TRI-LAKES MONUMENT FIRE PROTECTION DISTRICT

November 25, 2019

El Paso County Development Review
Attention: Rad Dickson
File Number: PPR1946

Applicant: Hellbusch Amended Site Development Plan
Jerome W. Hannigan and Associates, Inc.

# MONUMENT SMALL ENGINE STORAGE AMENDED SITE DEVELOPMENT PLAN

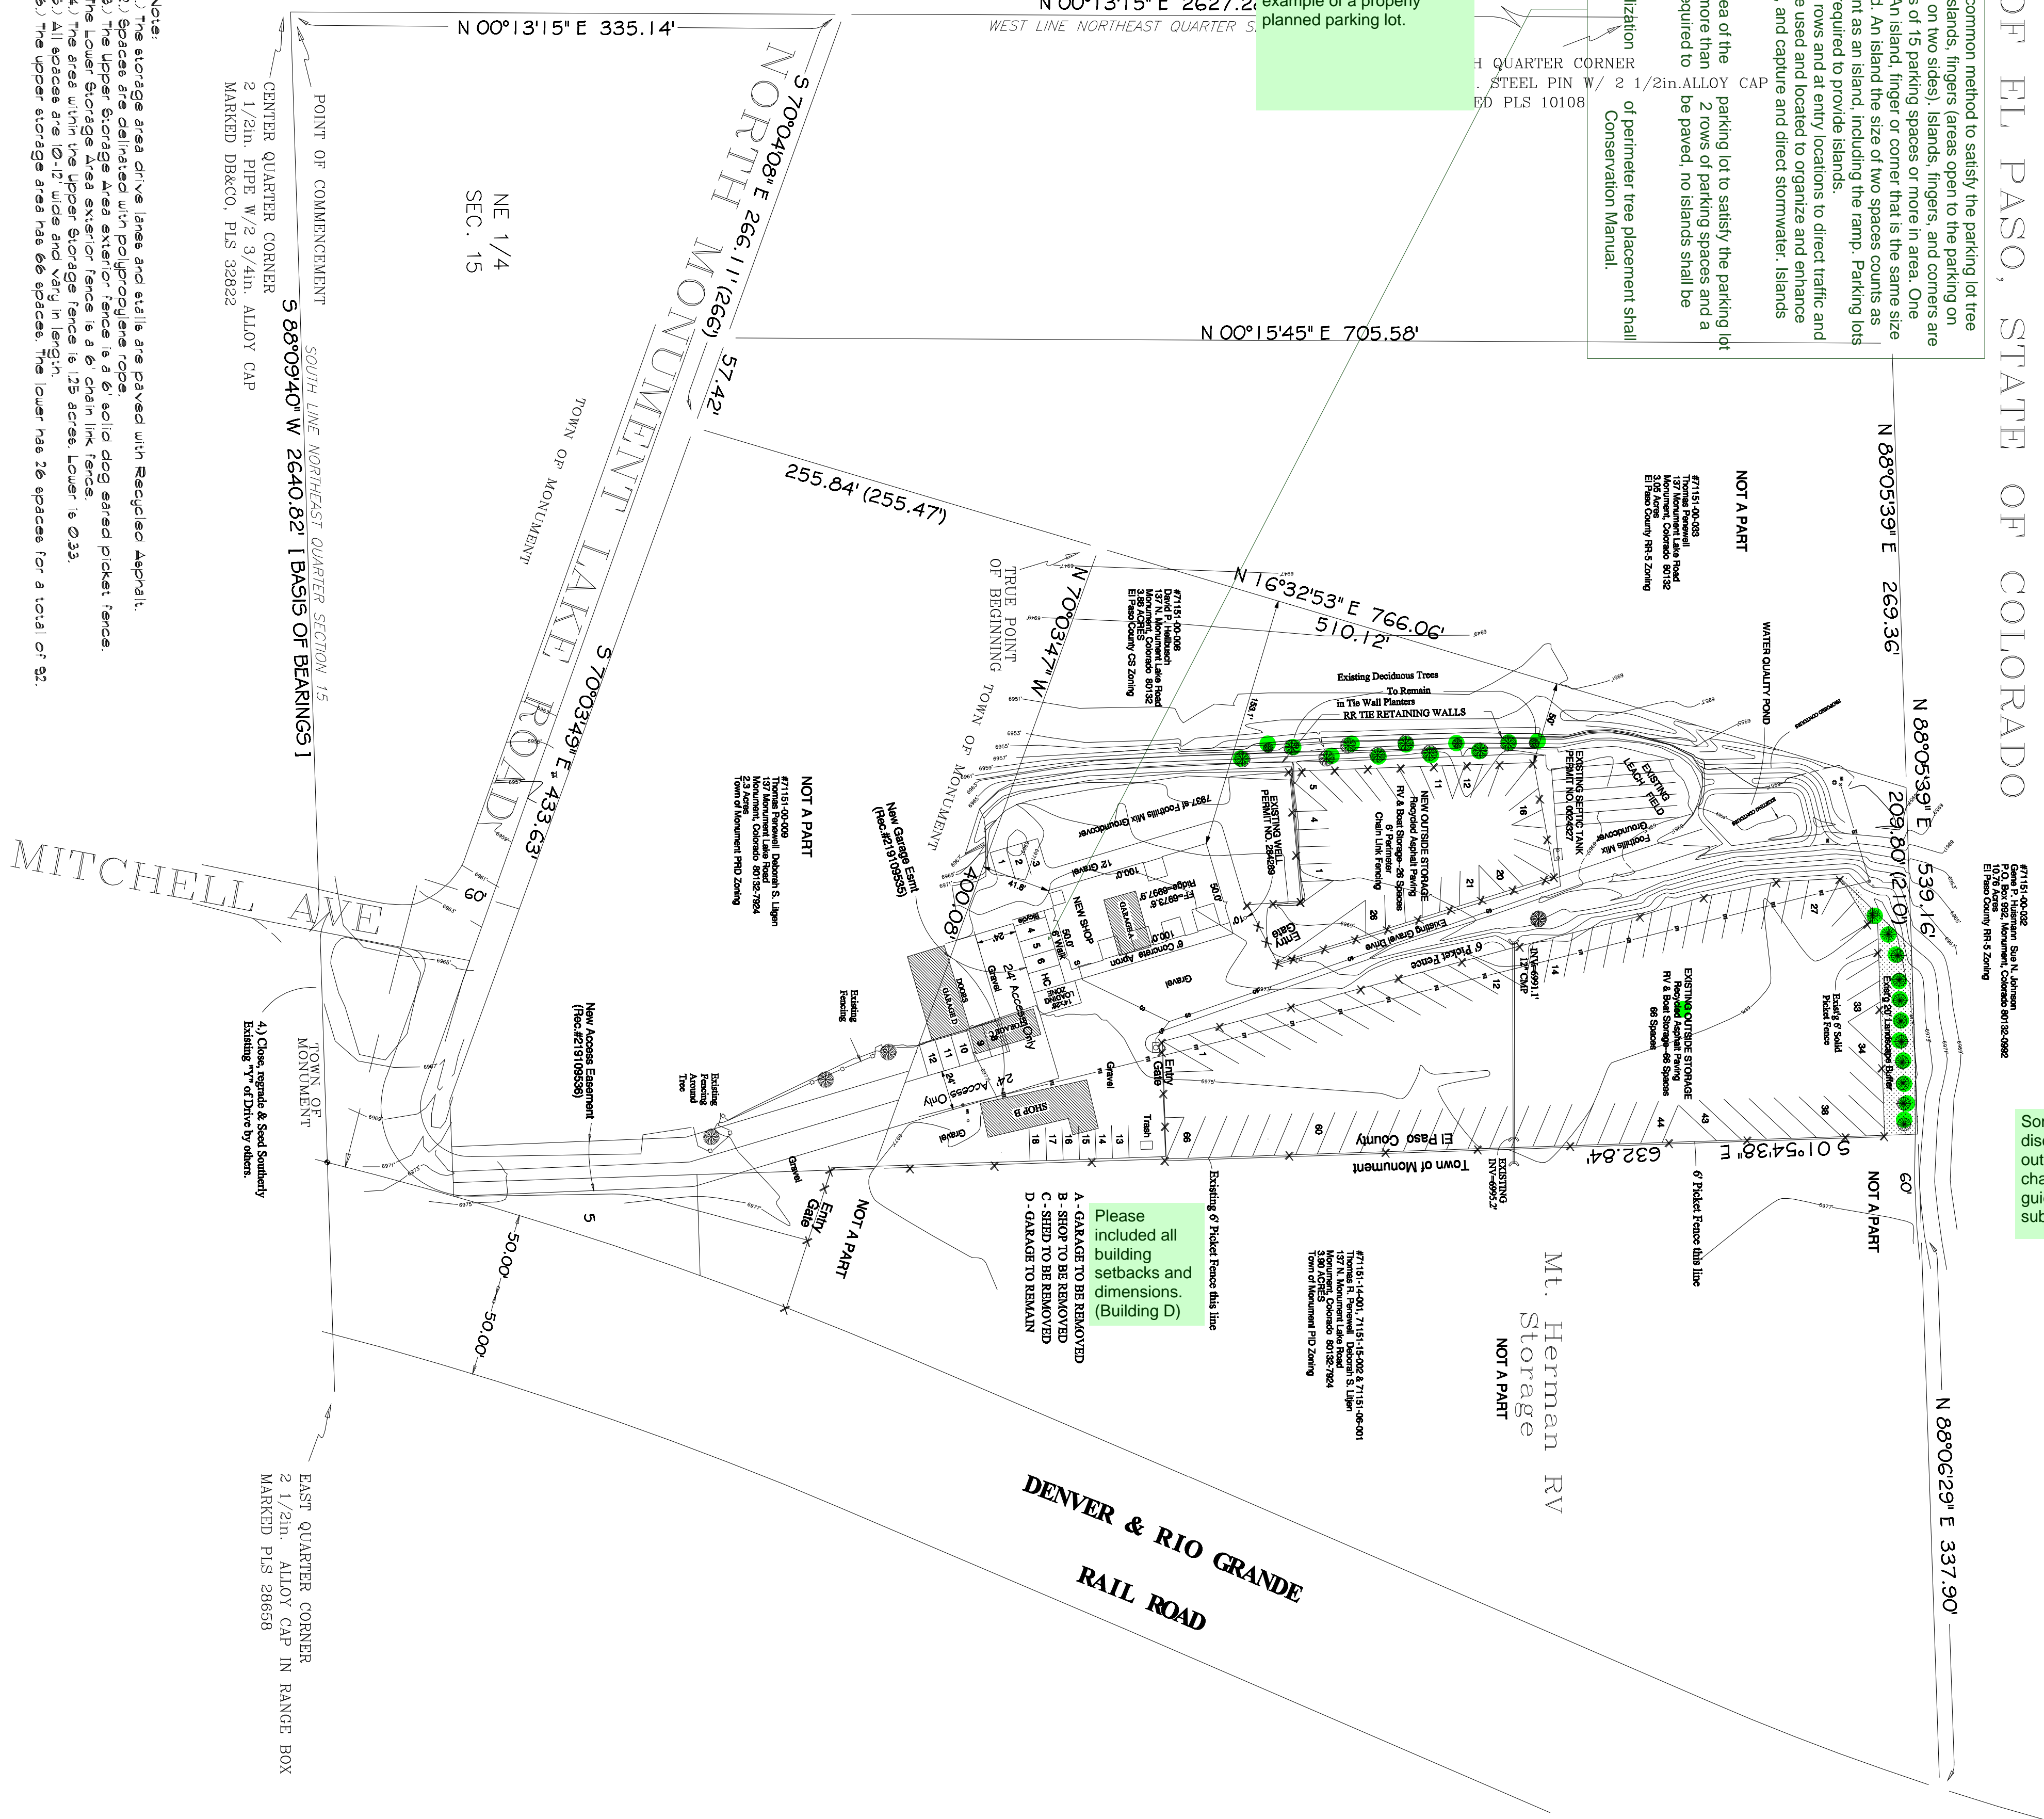
There is no mention of fire hydrants for the property, and it is difficult to determine the FD access through the roadways and gates.

2. Fire hydrant(s) spacing/location per Appendix B. Additional hydrant(s) required.
3. Hazardous Materials: IFC-09/Appendix H has been adopted and shall be completed and submitted with the construction permit drawings as necessary.

8. Coordination with this site and possible development of nearby site(s) should be considered for fire hydrant placement and spacing.
